**Date:** 11/10/2020

**Re:** **Soil Suitability for Foundation Installation**  
Location: Lot 11 Mason Pointe –  
48 Rawls Farm Lane, Fuquay-Varina, NC  
JDSfaulkner Project No.: RDU2009571  
Date of Inspection: 07/31/2020;  
08/07/2020; 10/2/2020; 10/14/2020  
Foundation Type: Rear Deck Footing

CRAWL SPACE FOUNDATION PLAN - 'D'
SCALE: 1/8"=1'-0"

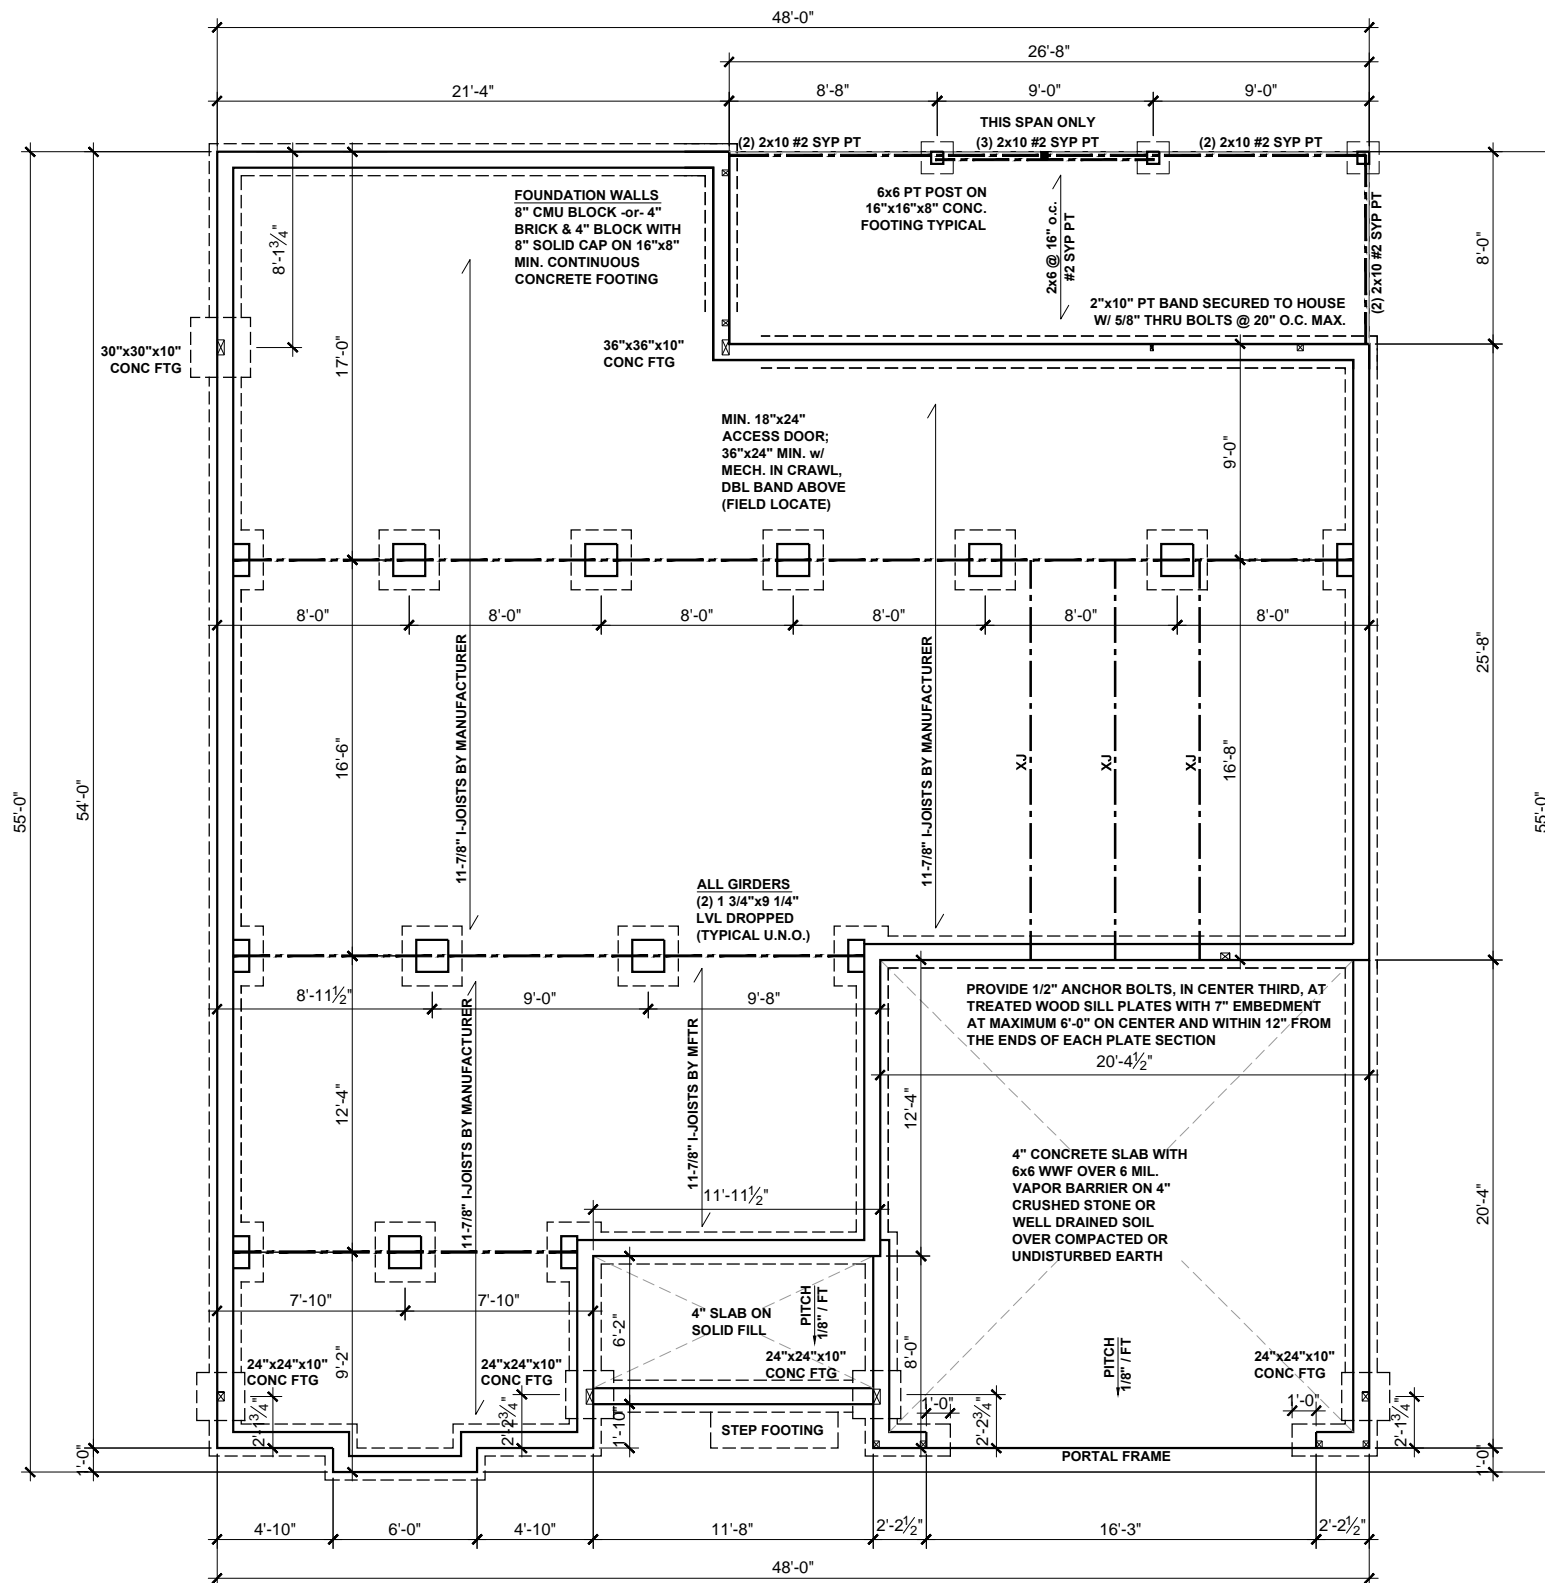
The exposed soils have been observed and tested for adequate bearing capacity (Probe and DCP). Based on our review and testing, the soil and conditions for the foundation are suitable for the minimum required bearing pressure of 2000 psf for the rear deck footing only. Additionally, the over-excavated areas (rear deck, 3 ft to 4 ft) may be back-filled with clean-washed #57 stone.

Note: footing width was increased to 34" and made into a continuous footing, which is an adequate substitute for the deck pier footings.
